**Consultation Response from KC,
Lead Local Flood Authority**

2024/93156 Healey Lane Mills, Healey Lane, Healey, Batley, WF17 7SH

Outline application for redevelopment of existing Islamic Centre

Date Responded: 18/12/2024.

Drainage Strategy

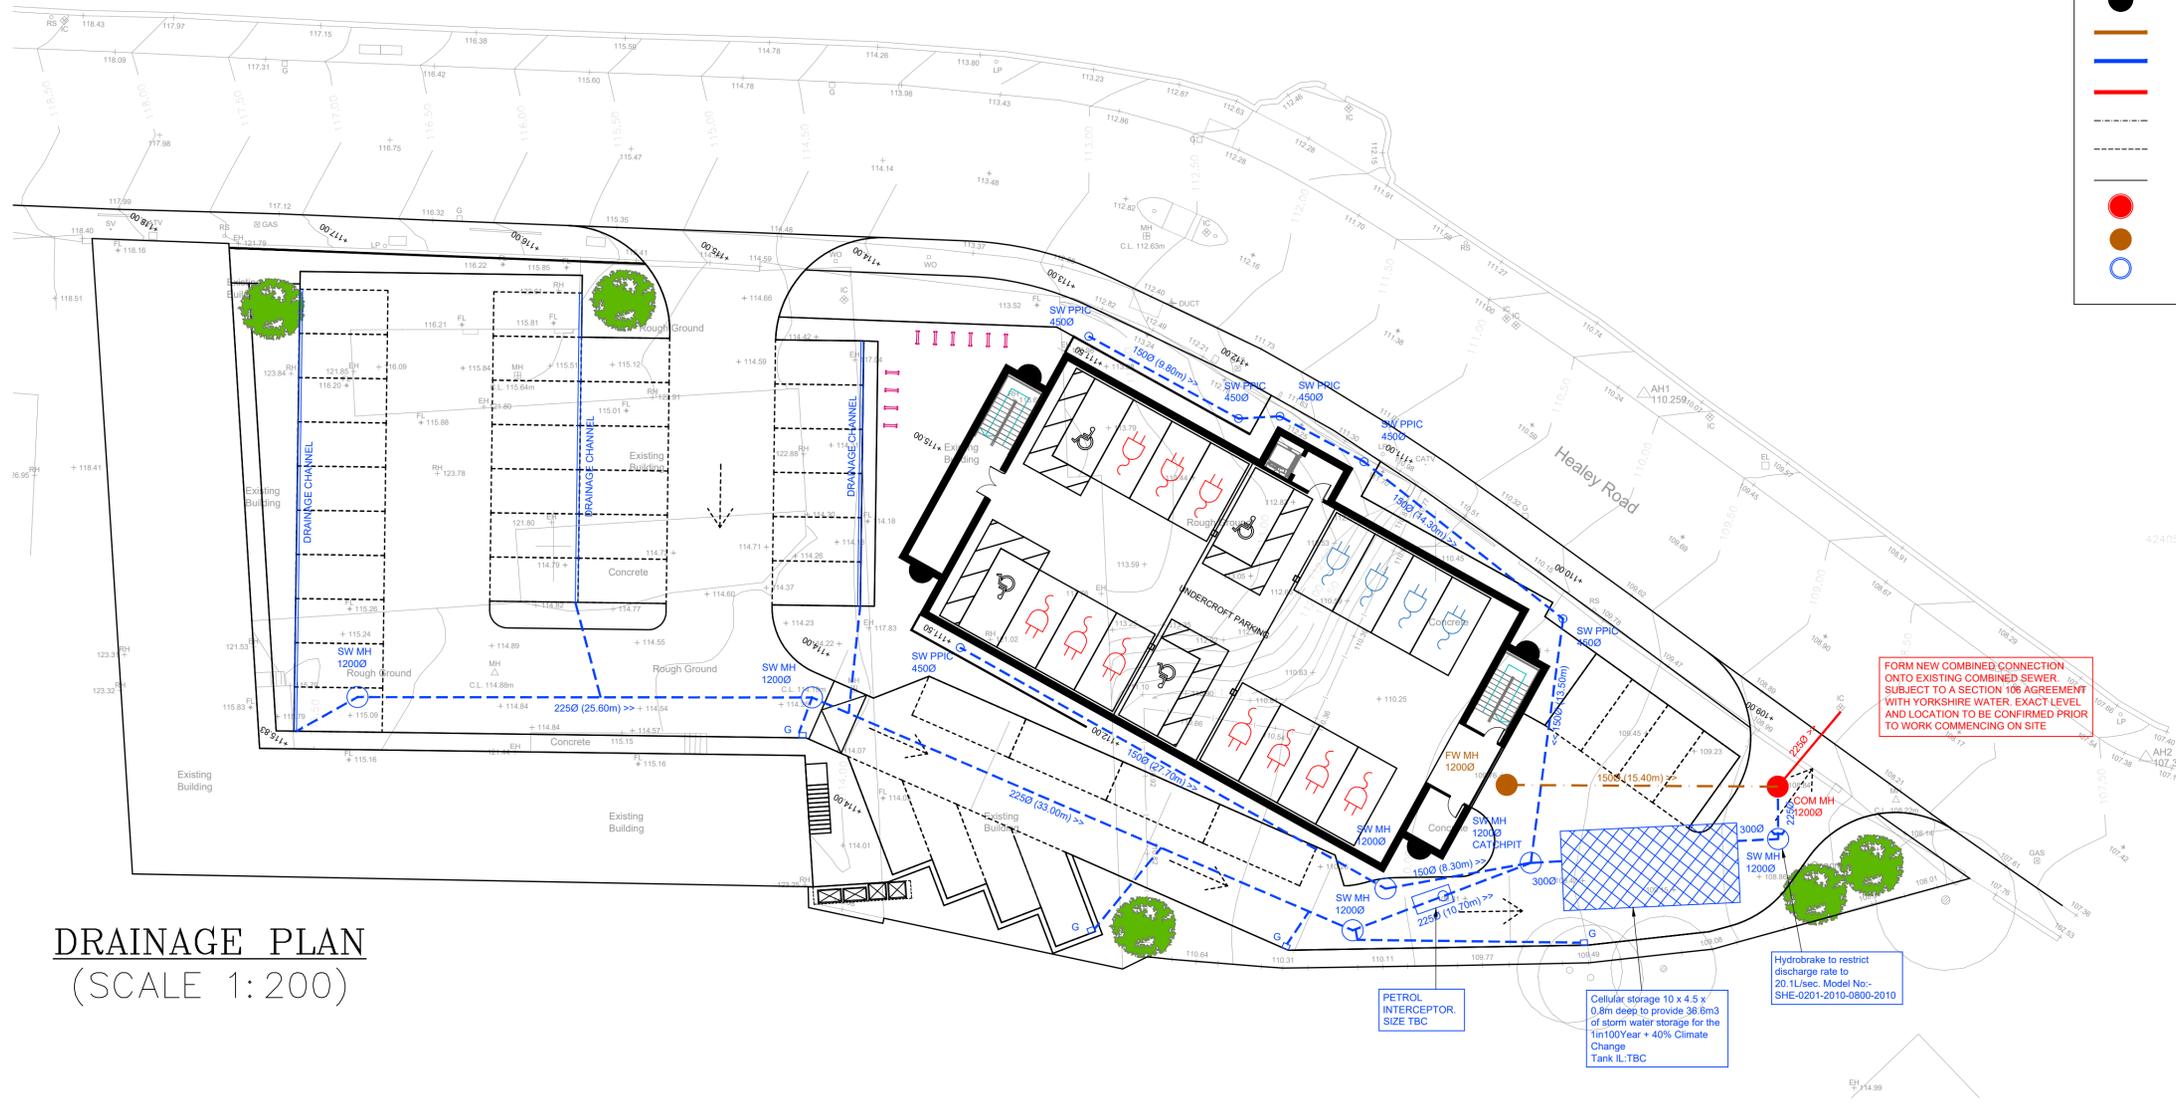
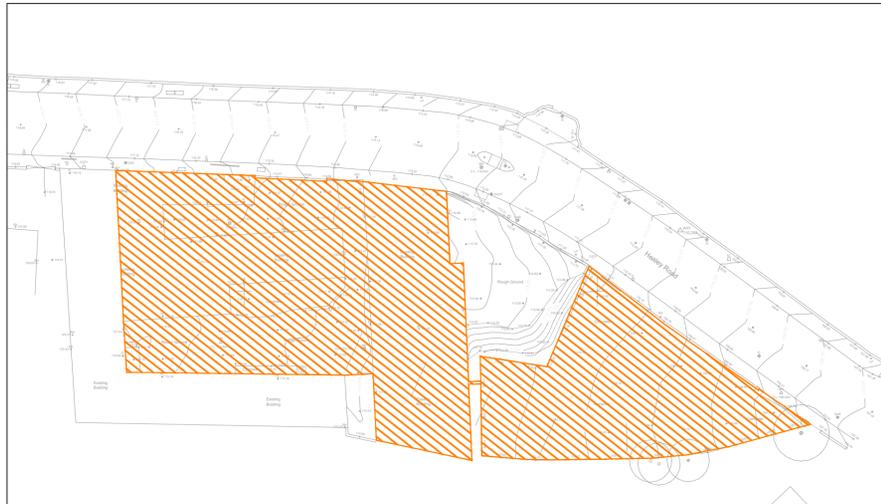
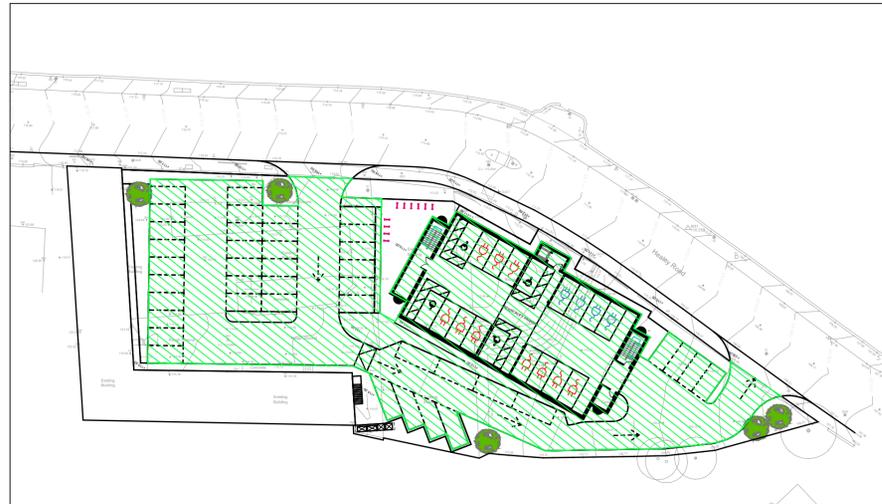
The LLFA confirms acceptance of the proposed attenuated surface water discharge rate of 20.1l/s and the discharge point to the 225mm dia Yorkshire Water combined sewer in Healey Road together with the submitted hydraulic calculations.

Details will need to be provided to the LLFA of the Maintenance Strategy and the organisation who will be responsible for the long term maintenance of the surface water system including the attenuation tank and the flow control device. The design parameters for the oil separator will need to be stated on the Drainage Strategy drawing together with the CLs and ILs of the surface water MHs.
